Ribble Valley Borough Council
Development Control
Council Offices Church Walk
Clitheroe
Lancashire
BB7 2RA

Our ref: NO/2012/104466/01-L01
Your ref: 3/2012/0910

**BRIDGE HEYWOOD CARAVAN PARK, DUNKIRK FARM, WHALLEY ROAD,
READ, LANCASHIRE, BB12 7RR - PROPOSED CHANGE OF USE OF LAND FOR
THE SITING OF 15 NEW STATIC HOLIDAY CARAVANS IN PLACE OF THE
STORAGE AREA WHICH WILL BE RELOCATED.**

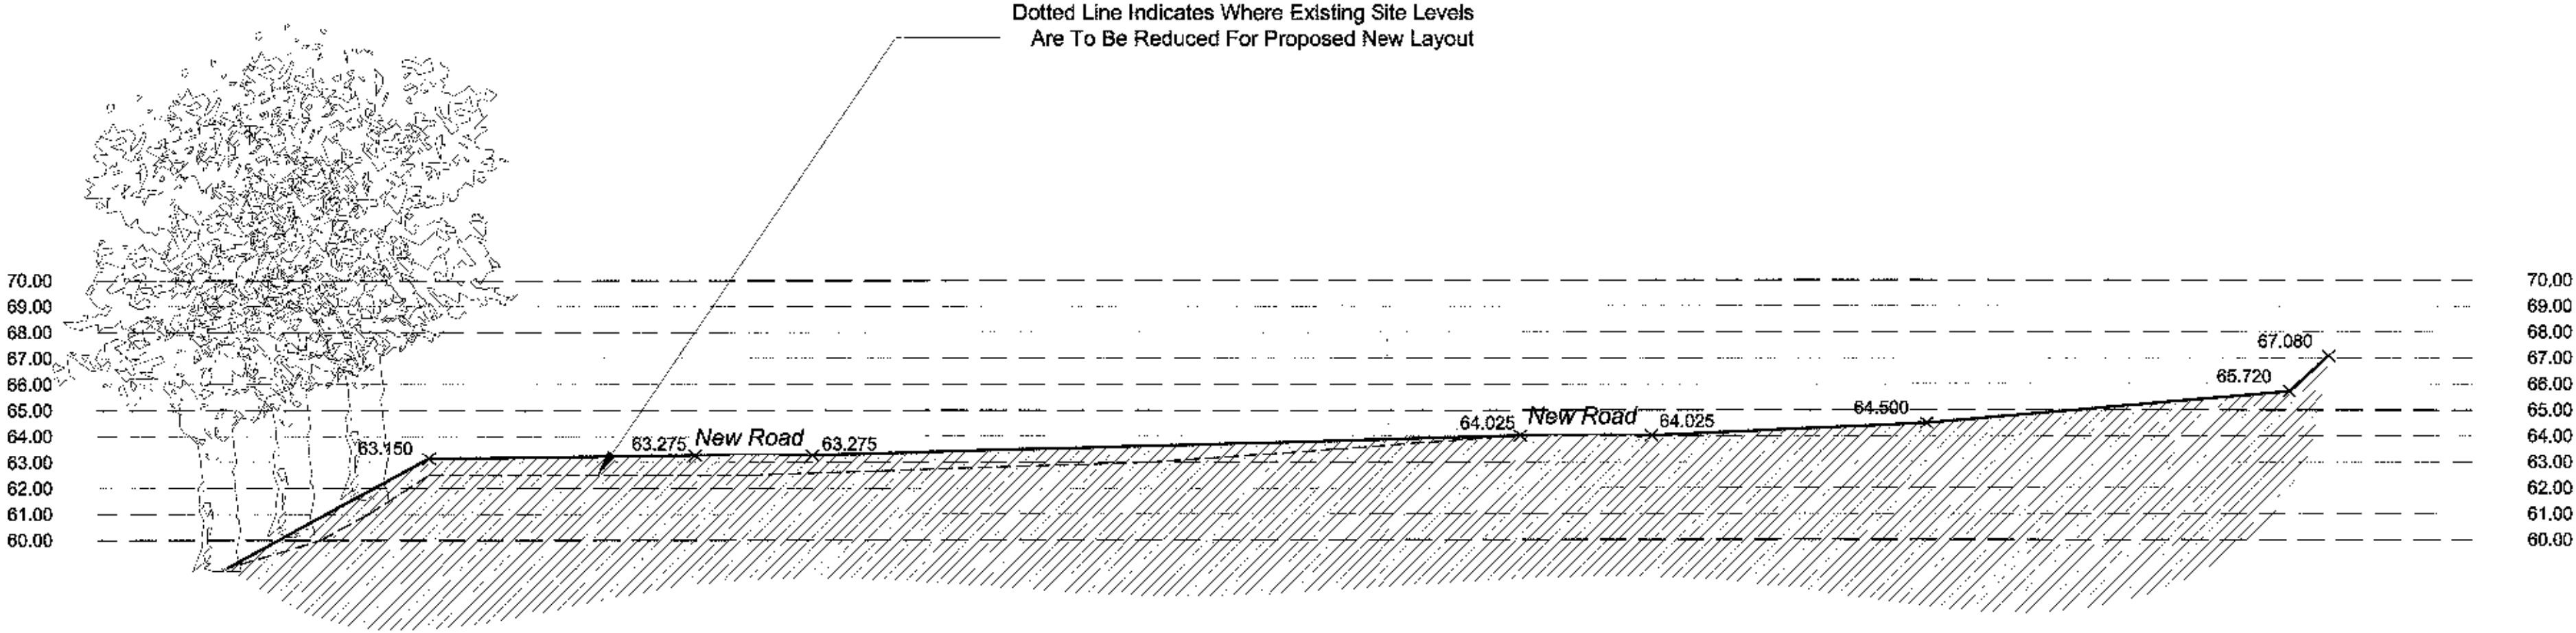
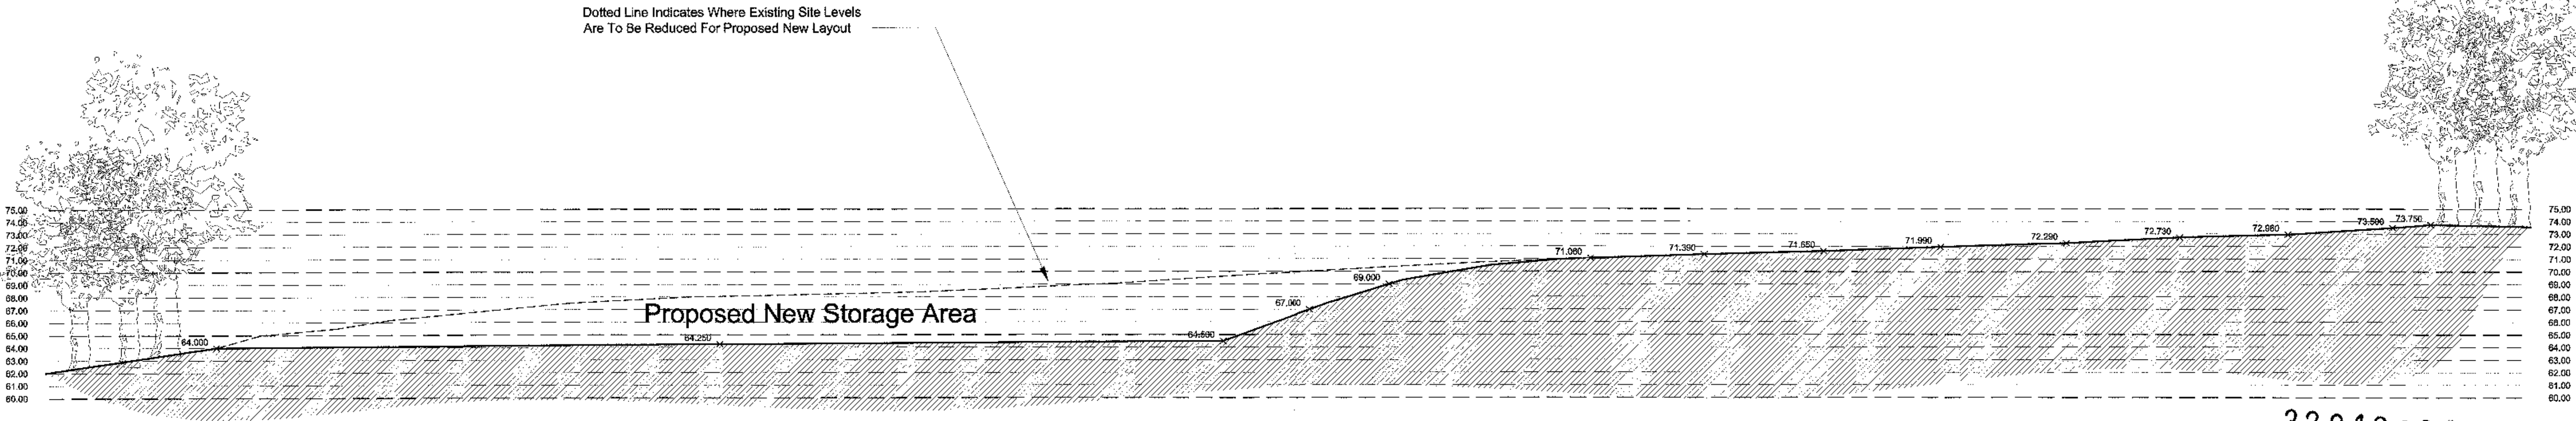
The site lies within Flood Zone 3a defined by the Technical Guide to the National Planning Policy Framework and has a high probability of flooding. Despite the mitigation measures proposed, the risk to life and/or property, within the development from fluvial inundation would be unacceptable if the development were to be permitted.

1. The proposed development does not have a safe means of access and/or egress in the event of flooding and no alternative option for managing the safety of people has been provided as part of the application. Consequently, there would be an unacceptable risk to the health and safety of the occupants in a flood event.

To be more resilient against flooding, the site area located within the floodplain would need to be raised by at least 600mm above the floodplain level and compensatory flood storage provided elsewhere on the site. There would also need to be a programme for maintenance to show that the watercourse flowing through the site would be cleared of debris on a regular basis.

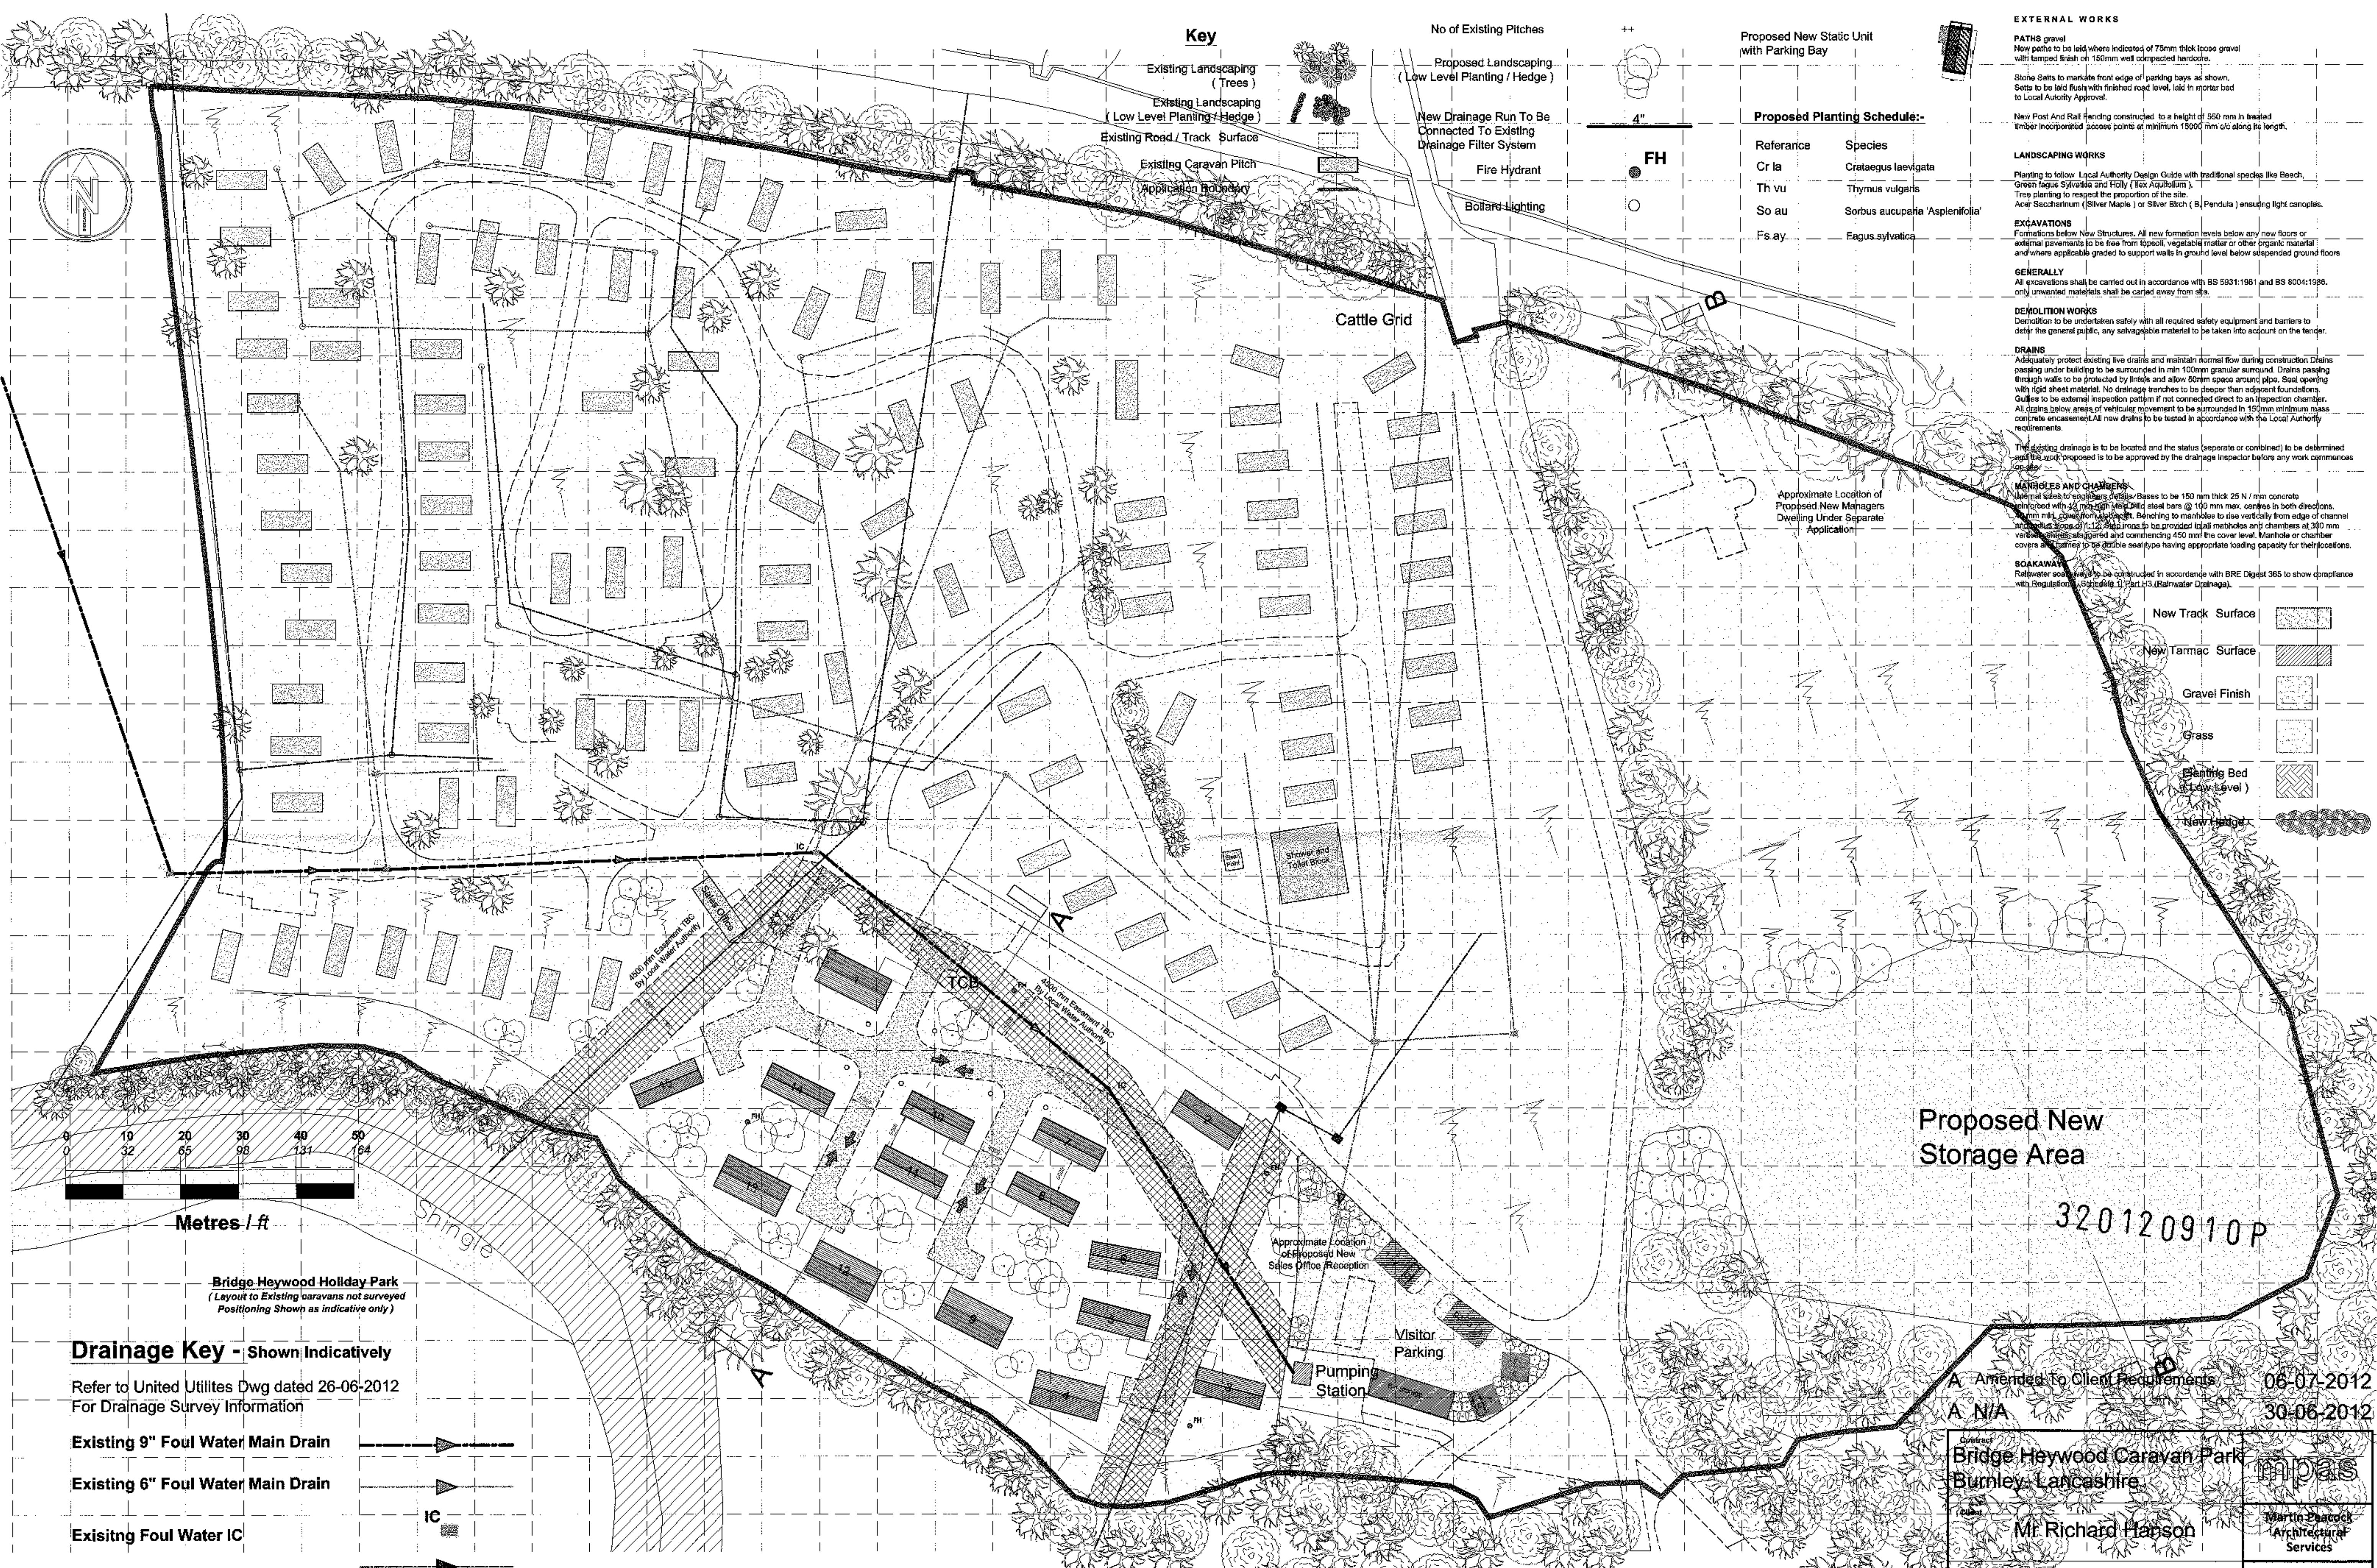
2. There is a risk that occupants of the caravans could be at risk from rising floodwaters, especially during the night.
3. The proposal includes siting caravans within 8 metres of the watercourse and would be unlikely to receive Environment Agency consent for the works because it would restrict essential maintenance and emergency access to the watercourse. The permanent retention of a continuous unobstructed area is an essential requirement for future maintenance and / or improvement works. Based on the information available it is unlikely the development can proceed as proposed.

The proposal would need to be amended to omit any works proposed to be carried out within 8 metres of the watercourse to maintain a clear and unobstructed means of access to the river.
